From: Contact Centre (CRM) <contact@ribblevalley.gov.uk>
Sent: 01 May 2022 17:53
To: Planning
Subject: Planning Application Comments - 3/2022/0271 and 3/2021/0595

Planning Application Reference No.: 3/2022/0271 and 3/2021/0595

Address of Development: Land off Preston Road, Ribchester

BOADICEA HOUSE PLAN

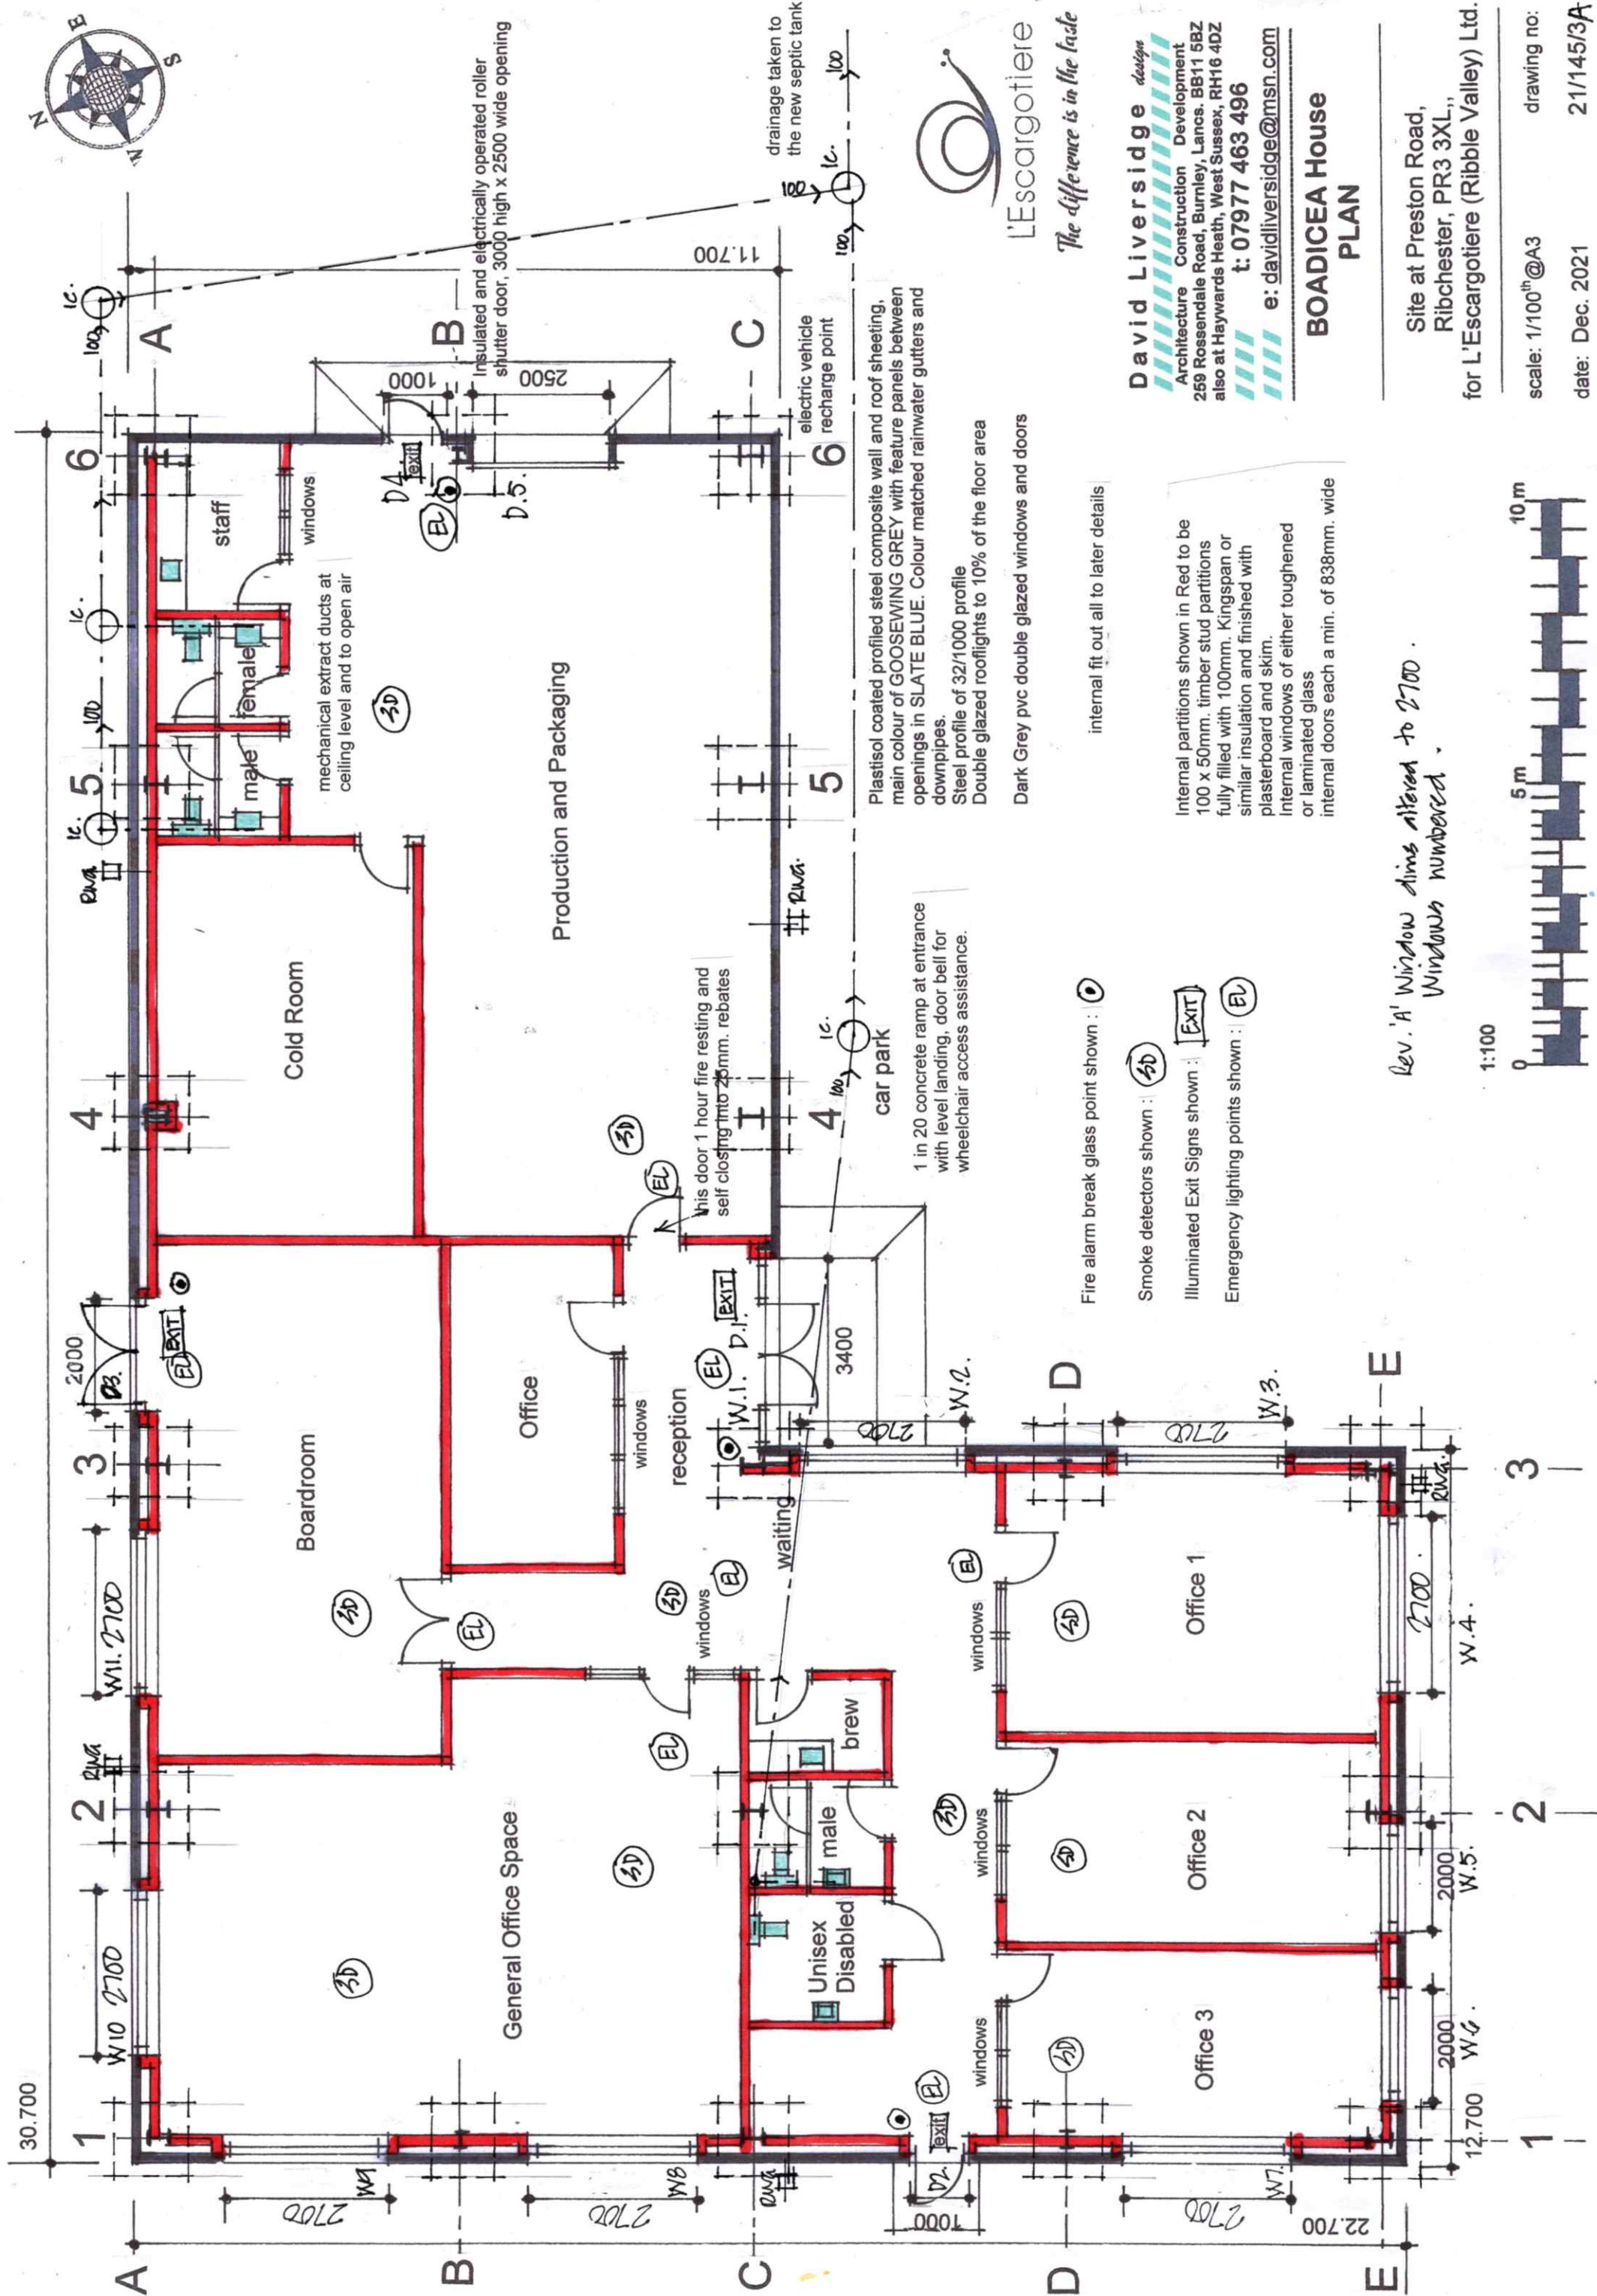
In this renewed application, however, the heliculture space has been reduced to less than a third of the building, with no less than five offices and a boardroom in the rest of the building.

It looks as though the application has morphed into a general office block, which is out of keeping with the Core Strategy's designation of Ribchester as a Tier 2 settlement.

2. The original application was approved with conditions. Condition 3 (which this application seeks to modify) stated that the external facing materials should be as applied for, to ensure materials are appropriate to the locality. We don't feel the proposed changes meet this condition at all.
